MP 05_0157, Moorebank Waste Facility

Construction and operation of a recycling facility that would handle approximately 500,000 tonnes of construction waste per year

Comments based on the documents available on the website

TITLE
 DESIGN LEVELS *Lot 6*
 LOT 1 D.P. 336643 *DP 1065574*
 NEWBRIDGE ROAD
 MOOREBANK

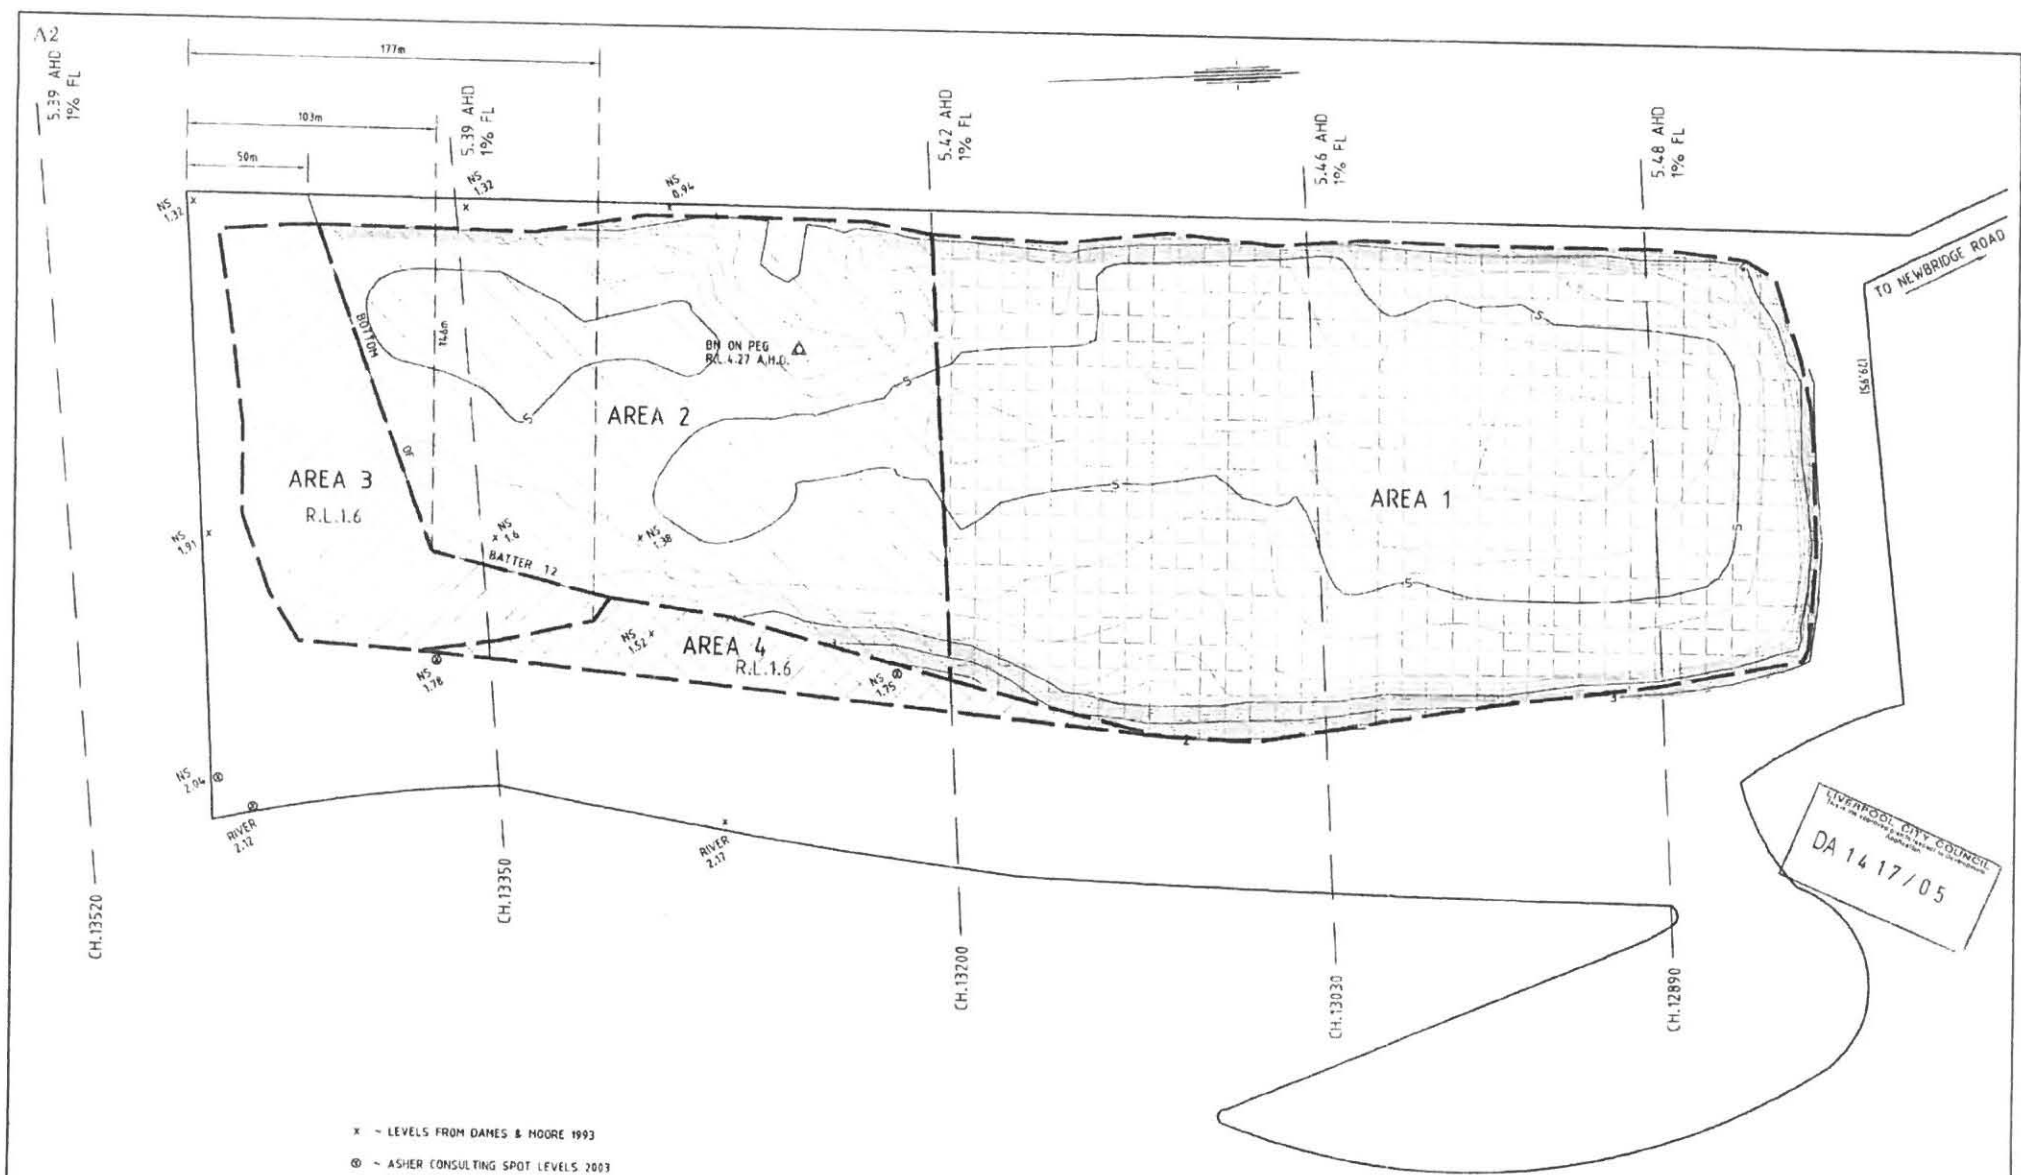
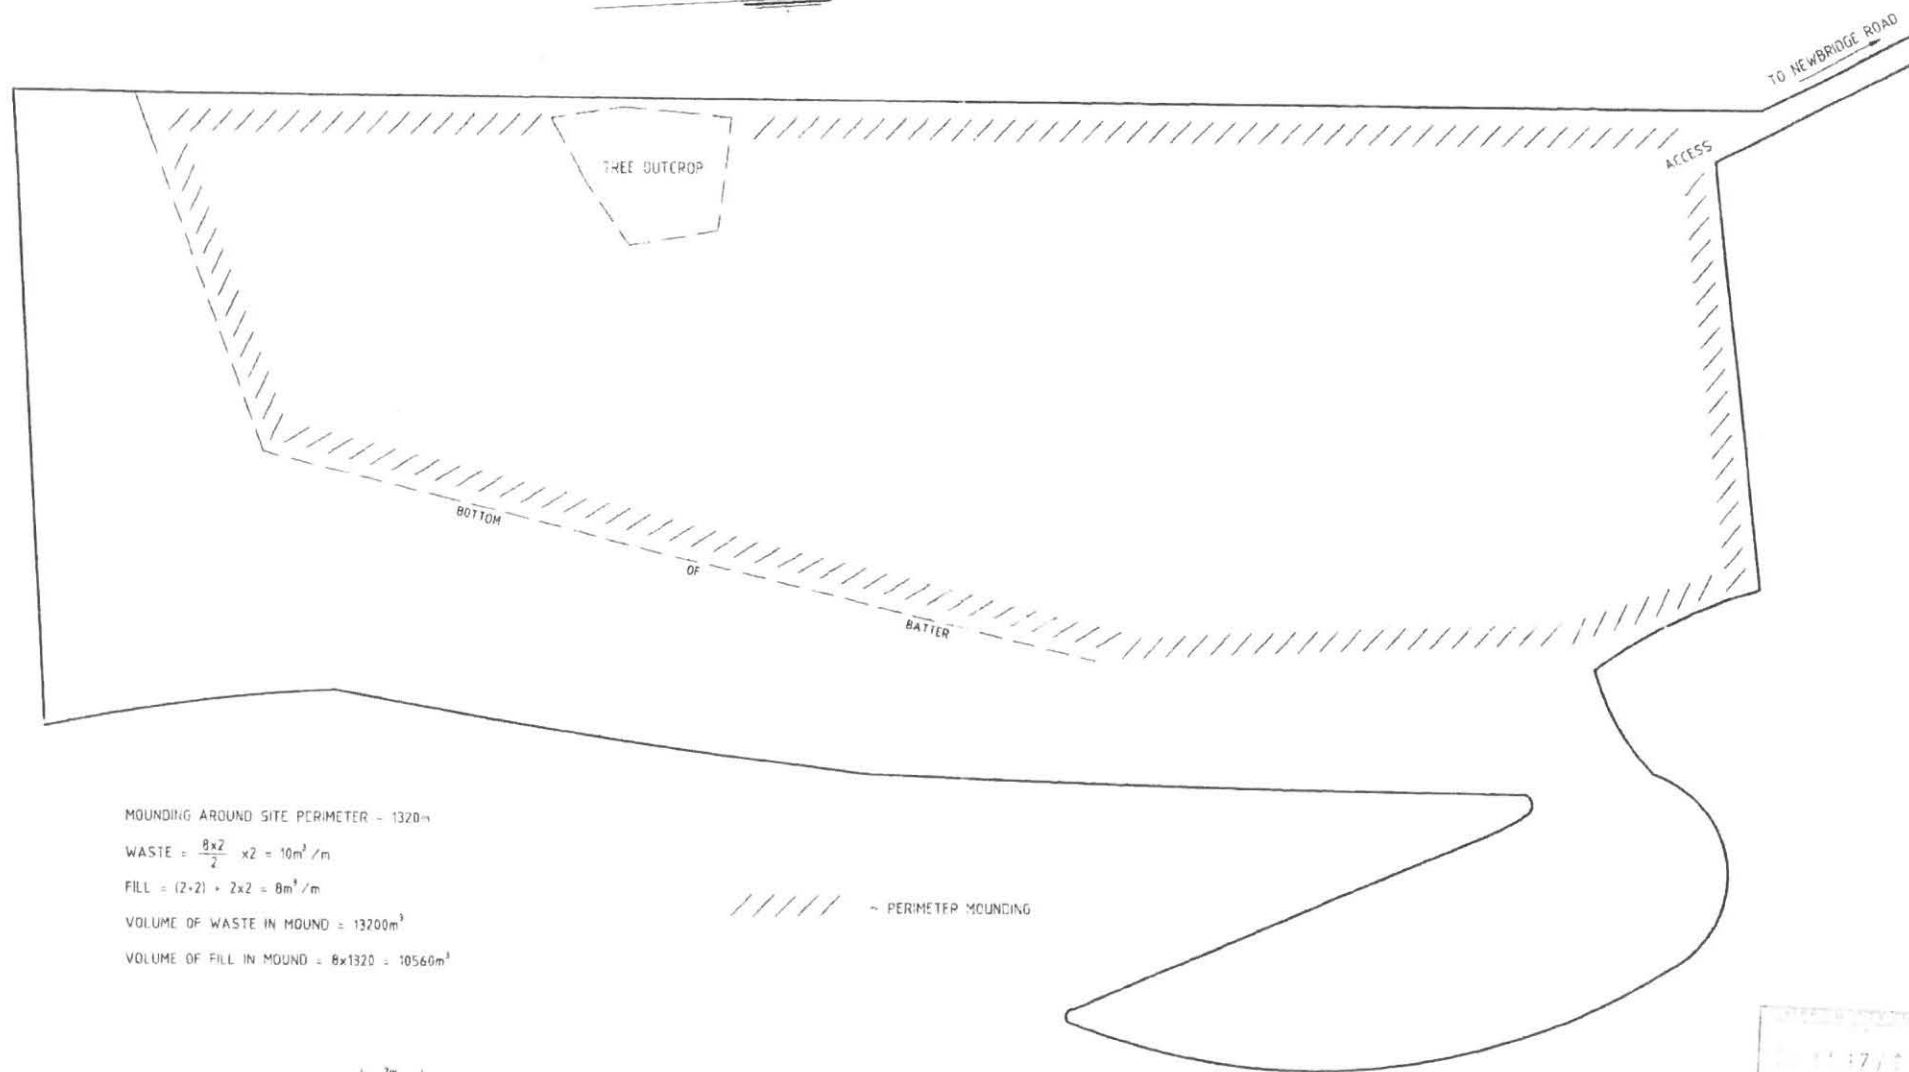
- **Proposed Layout:** A 4m mound along the site boundary has been proposed. This seems grossly inadequate as most of the proposed structures e.g crushers, workshop etc are double of this height. This mound will not be able to screen neither noise nor emissions arising from the proposed facility.
